**ADC PARKS & GREENSPACE ARBORICULTURE**

PLANNING APPLICATION: LU/223/14/PL

ADDRESS: Land north of 52-67 Greenfields, Littlehampton, BN17 7JG

BRIEF DESCRIPTION: Application under regulation 3 of the town and country planning regulations 1992 for the erection of 8No. Houses and associated parking, hard and soft landscaping, on an existing parking court.

DRAWING NO. J48.22/02
Scale: 1:200 at A3
Added to by: NL
03/02/2014

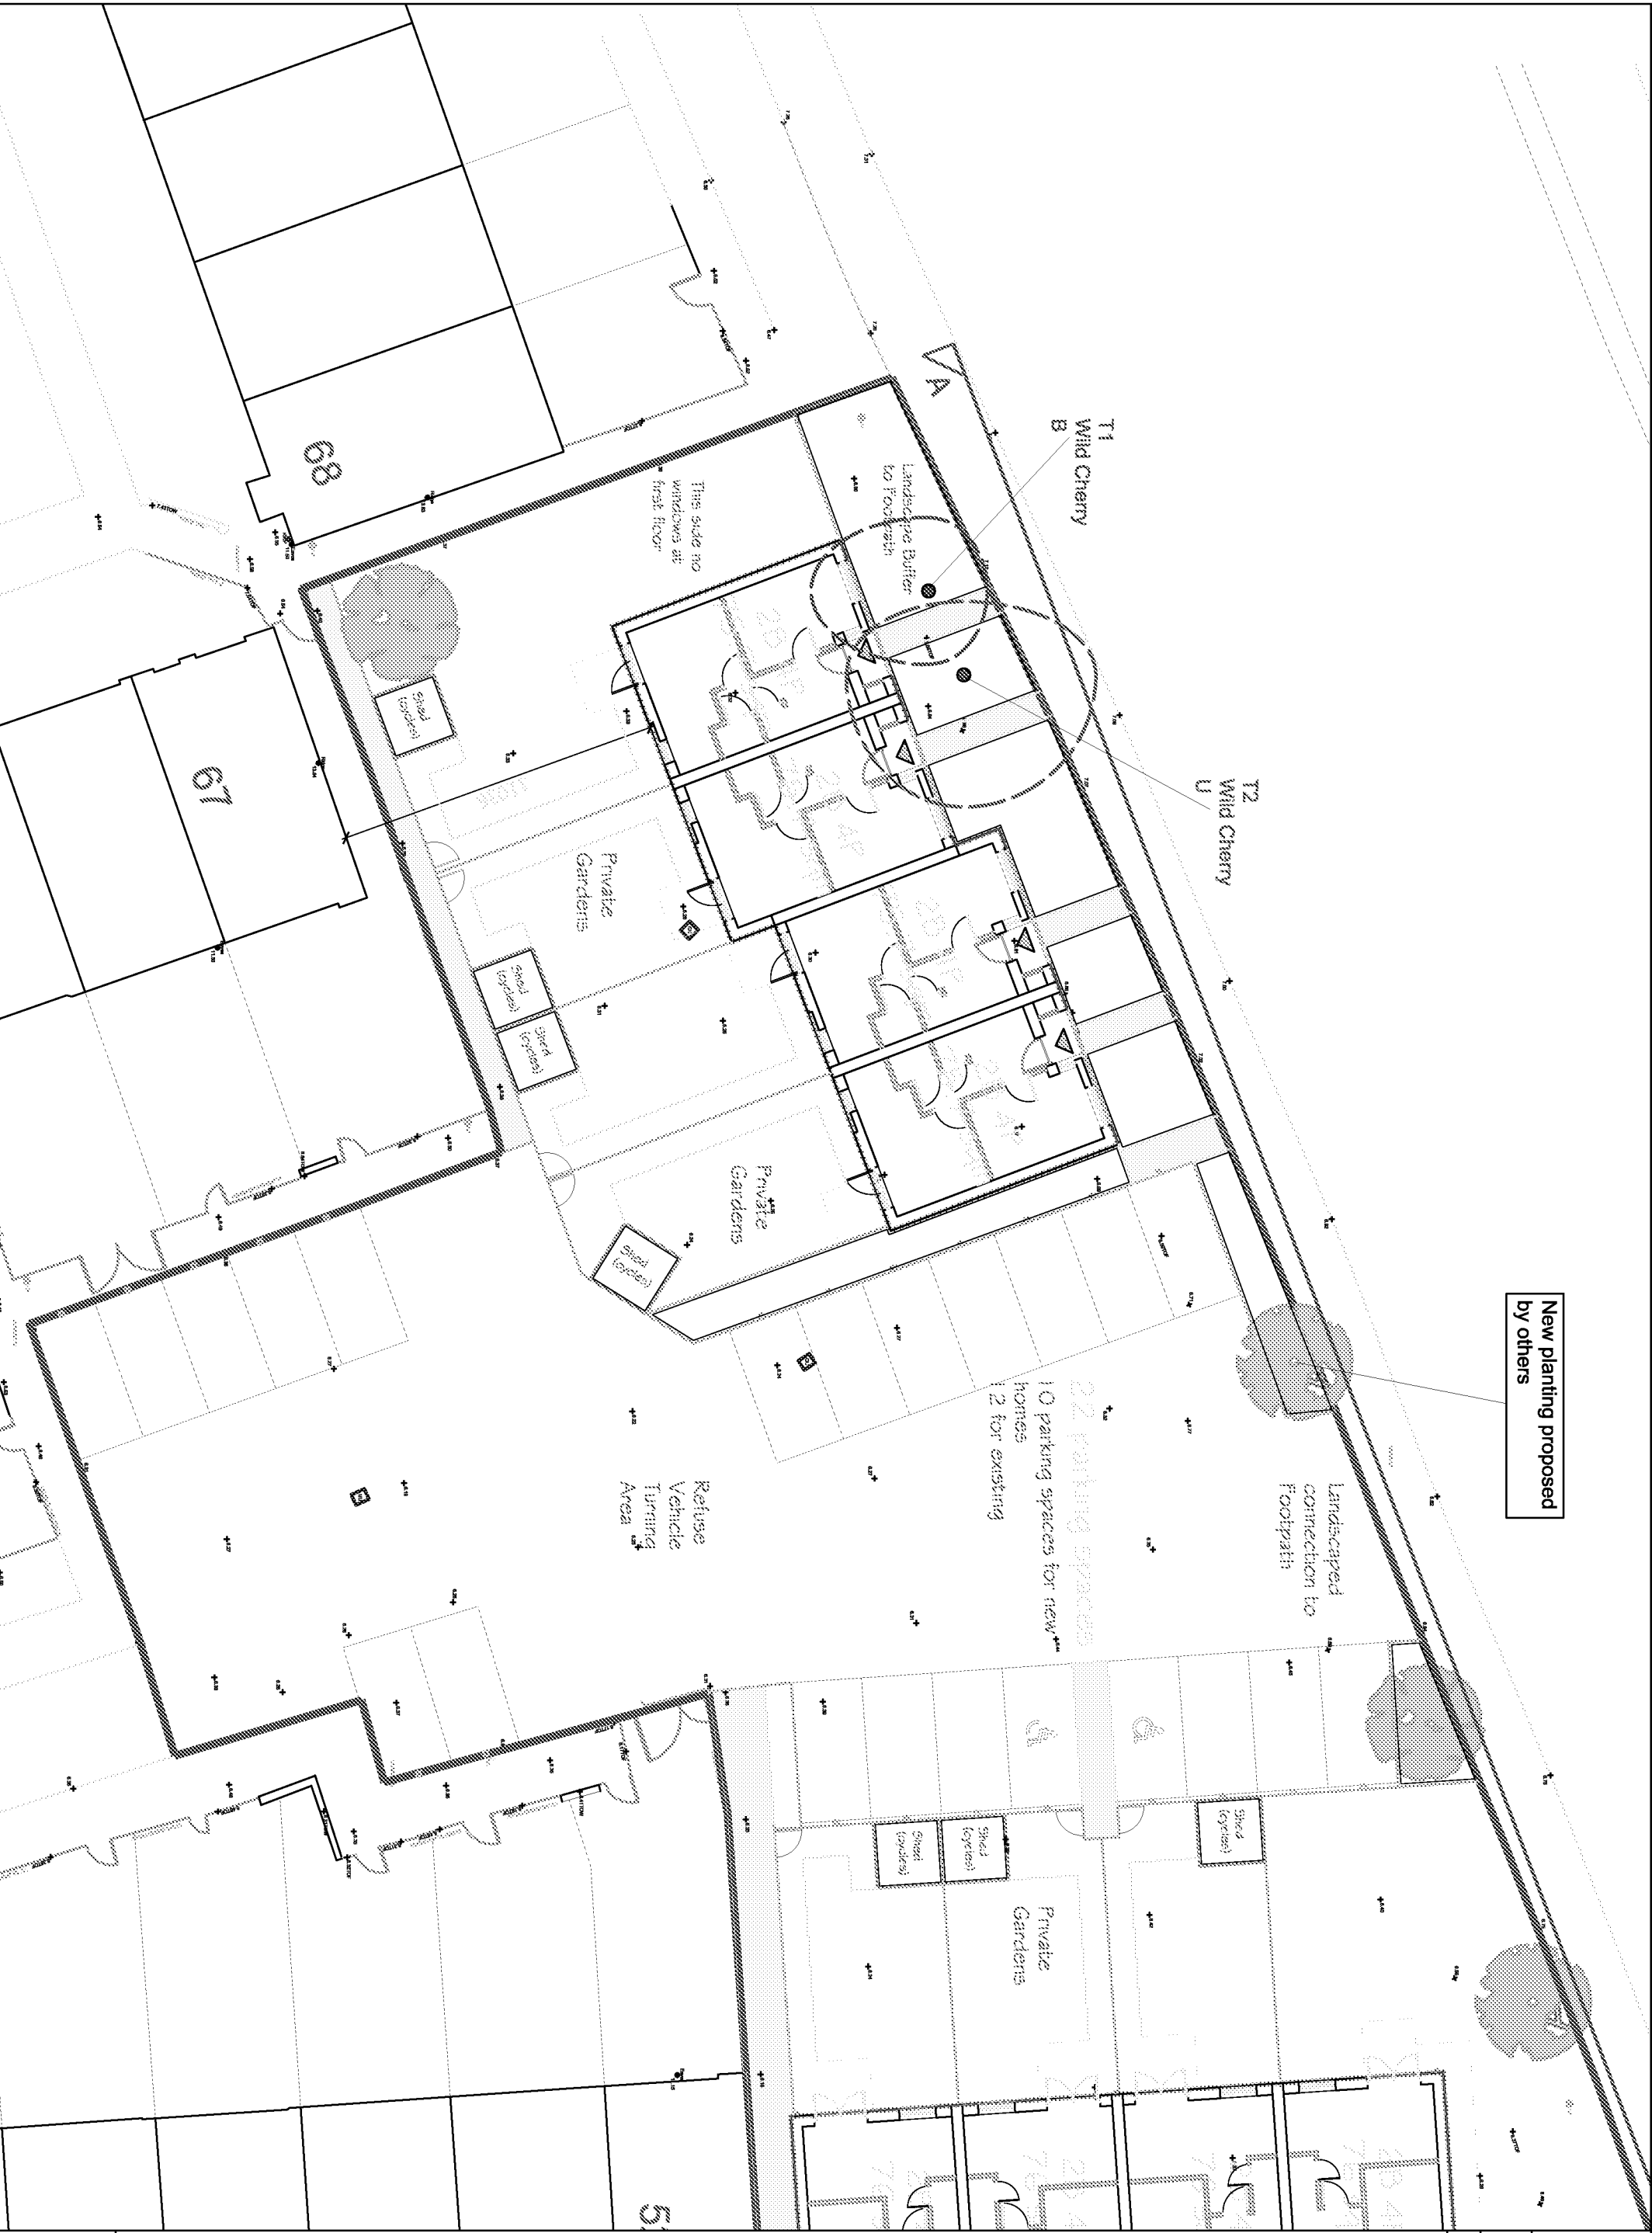
- The Arboricultural report submitted outlines in detail all relevant requirements that BS5837 places on the retained trees in demolition/construction environment. The submitted arboricultural report also correctly identifies T-1 for retention, and T-2 for removal (due to its poor form and health)
- All trees that are being looking to be retained have correctly sized RPA's, and methods of working within the RPA's has been clearly defined (use of hand tools in these areas etc.).

- If all the actions are implemented from Root protection plan and Tree survey schedule, **I see no issue with the current schedule of works** and would **therefore be happy to allow the proposed works to take place**, as reasonable measures have been implemented to protect the outlined trees that are to be retained.
- I also agree with the analysis that T-2 should be remove based on its arboricultural merit

- **All works are to comply with BS5837:2012 – Trees in relation to design, demolition and construction –Recommendations**
- I would also like to place the condition that **once the RPA protection has been established, that the Local Authority is contacted so an inspection of the mitigation can take place** prior to any construction works beginning. Additional visits can be arranged after this visit.
